18 December 2019

Reference: SSI-9737 Sydney Gateway – Conditions of Approval

Thank you for the opportunity to review and comment on the Environmental Impact Statement for the proposed Sydney Gateway Project. The following are our comments.

Figure 14.8 Change in inundation due to the project during a one per cent AEP flood event

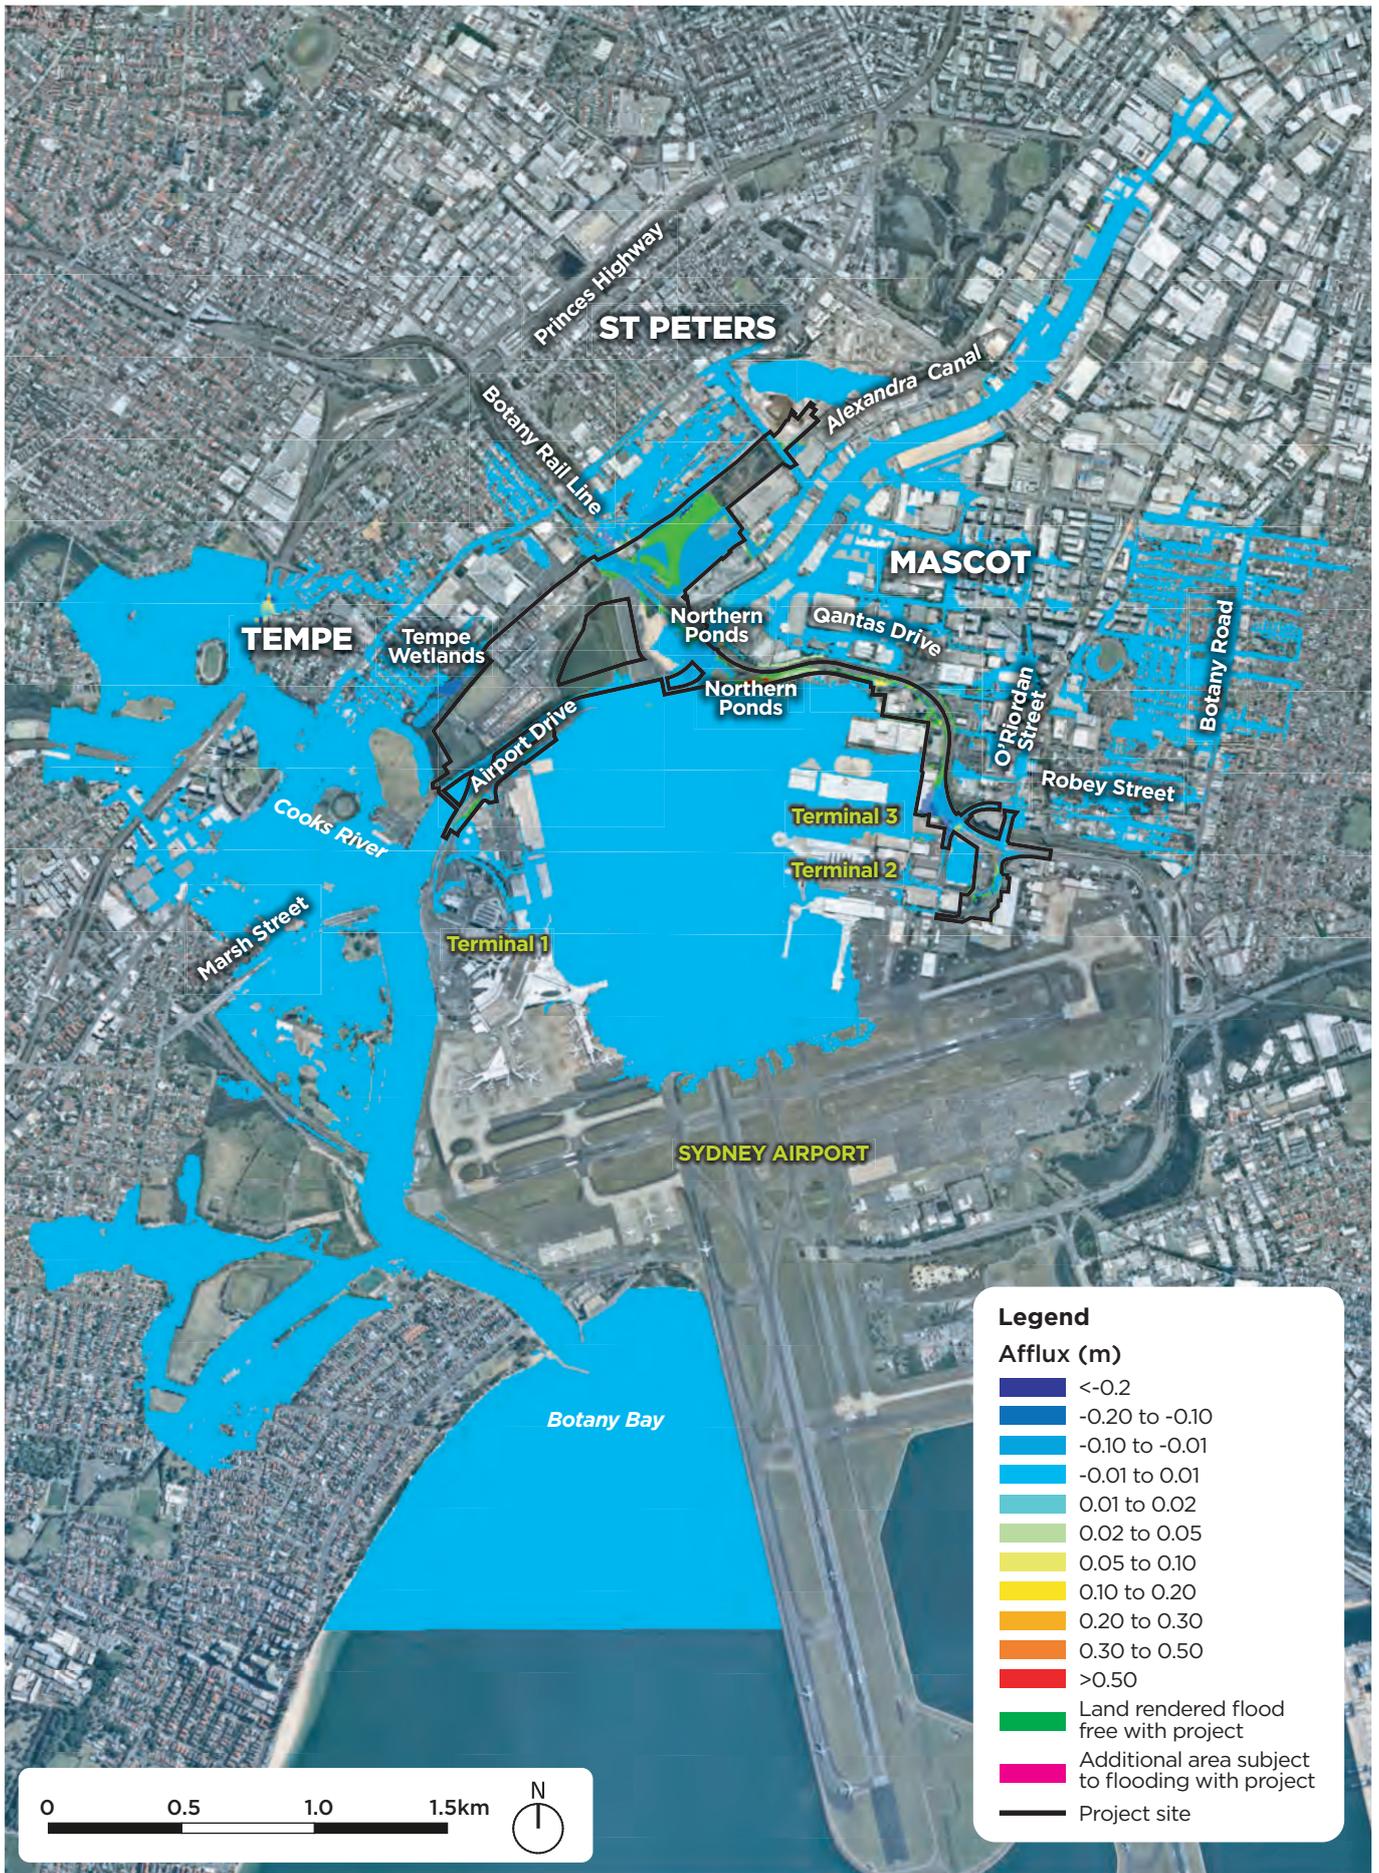
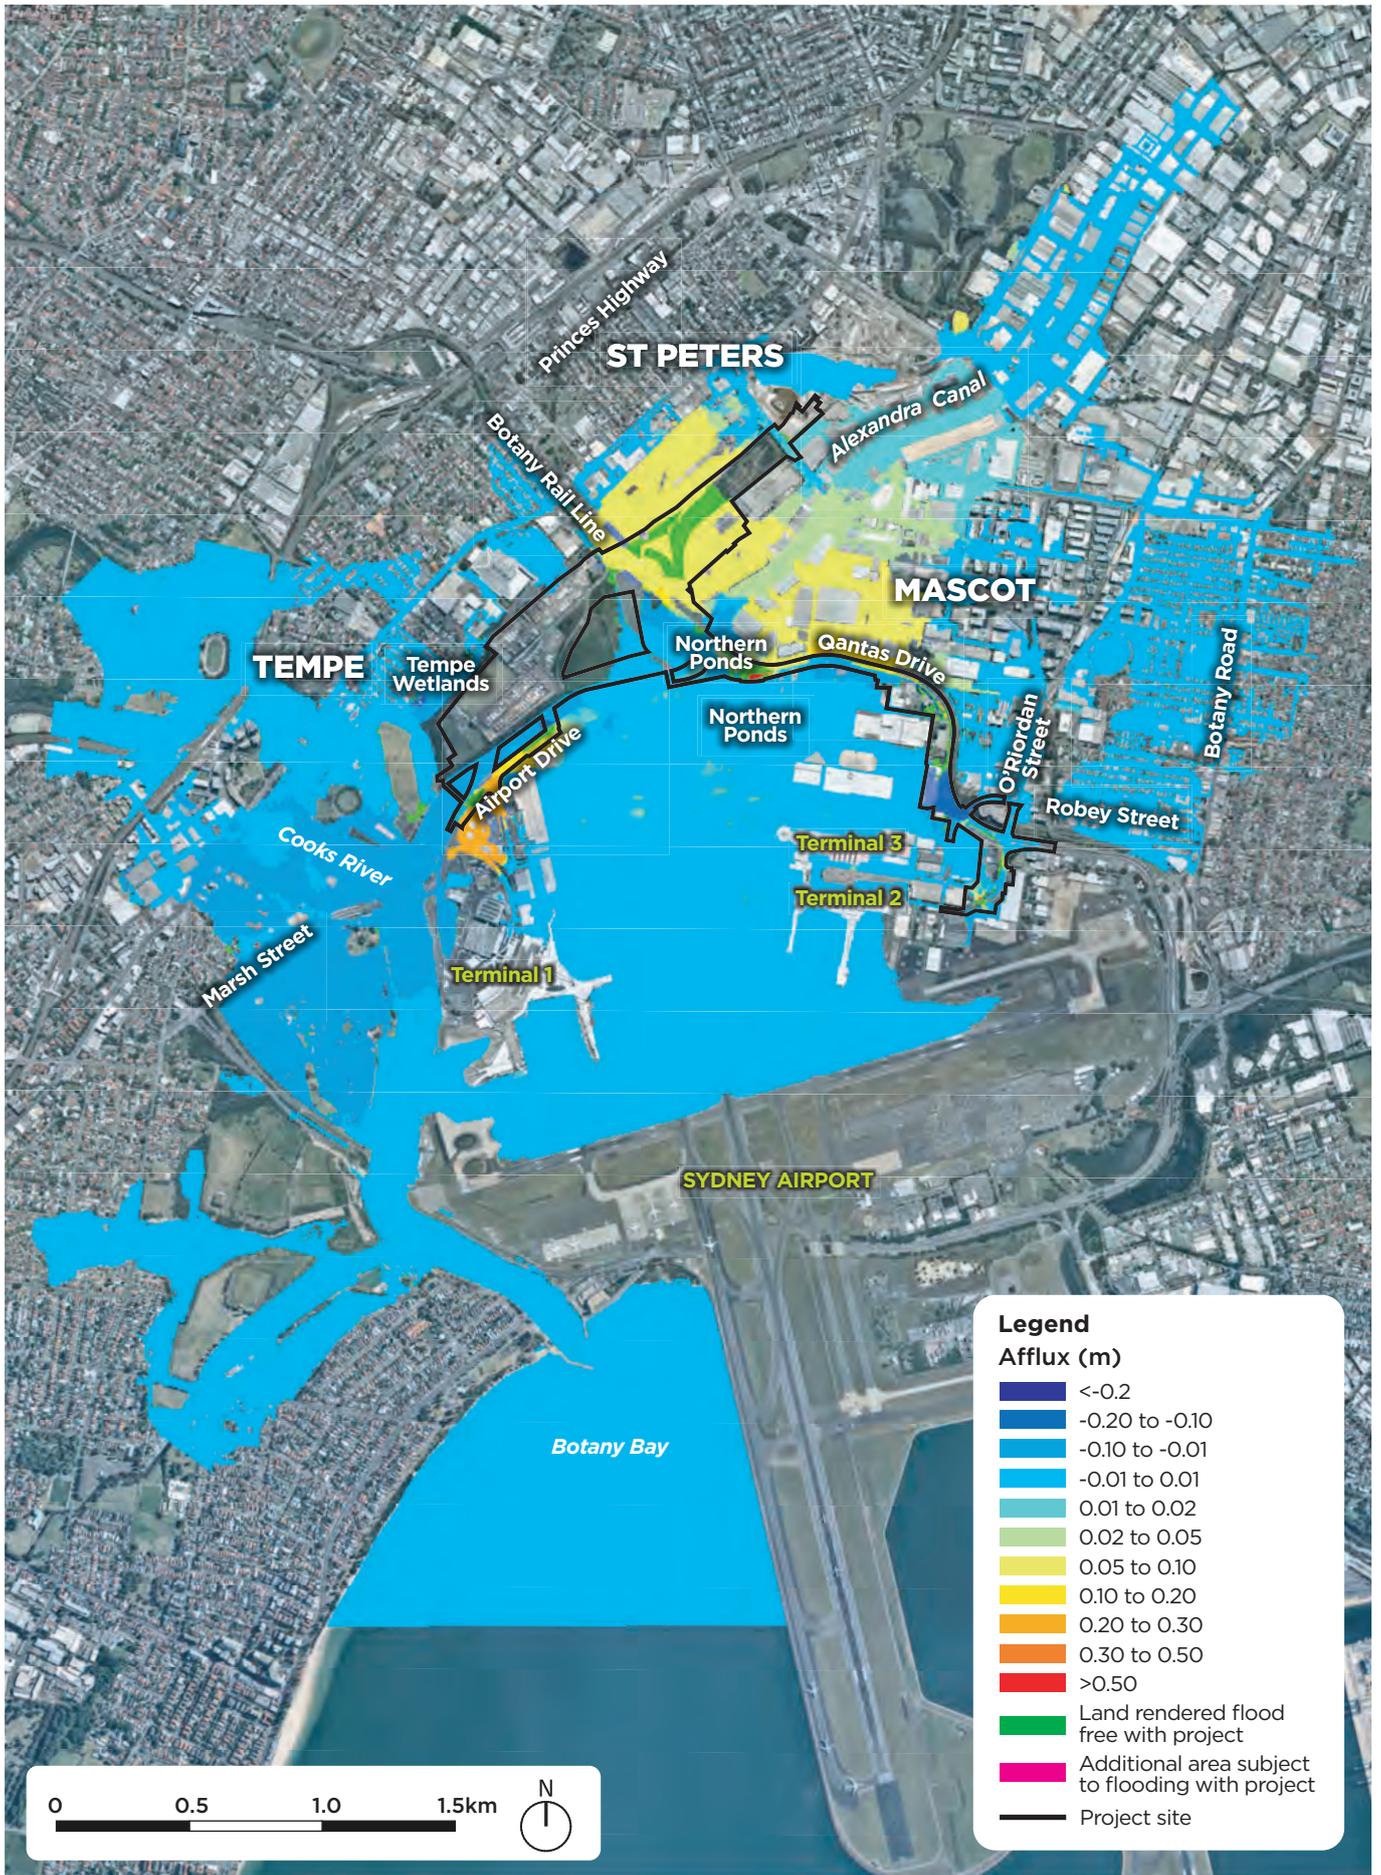
- Sydney Water requires evidence that the freight terminal bridge shown in Figure 7.24 in Chapter 7 will not have adverse impacts to flooding in the area, particularly in relation to Alexandra Canal. This is directly in relation to the bridge and the concrete wall adjacent to the canal illustrated in the render.
- Chapter 14: there is a discrepancy between what TfNSW state as the potential peak flood level to Alexandra Canal south of the Botany Rail Line. On part 14.17, a peak

flood level of 0.04m is stated and on part 14.13 a peak flood level of 0.02m is stated. TfNSW to confirm and advise whether these impacts are confined to the Alexandra Canal.
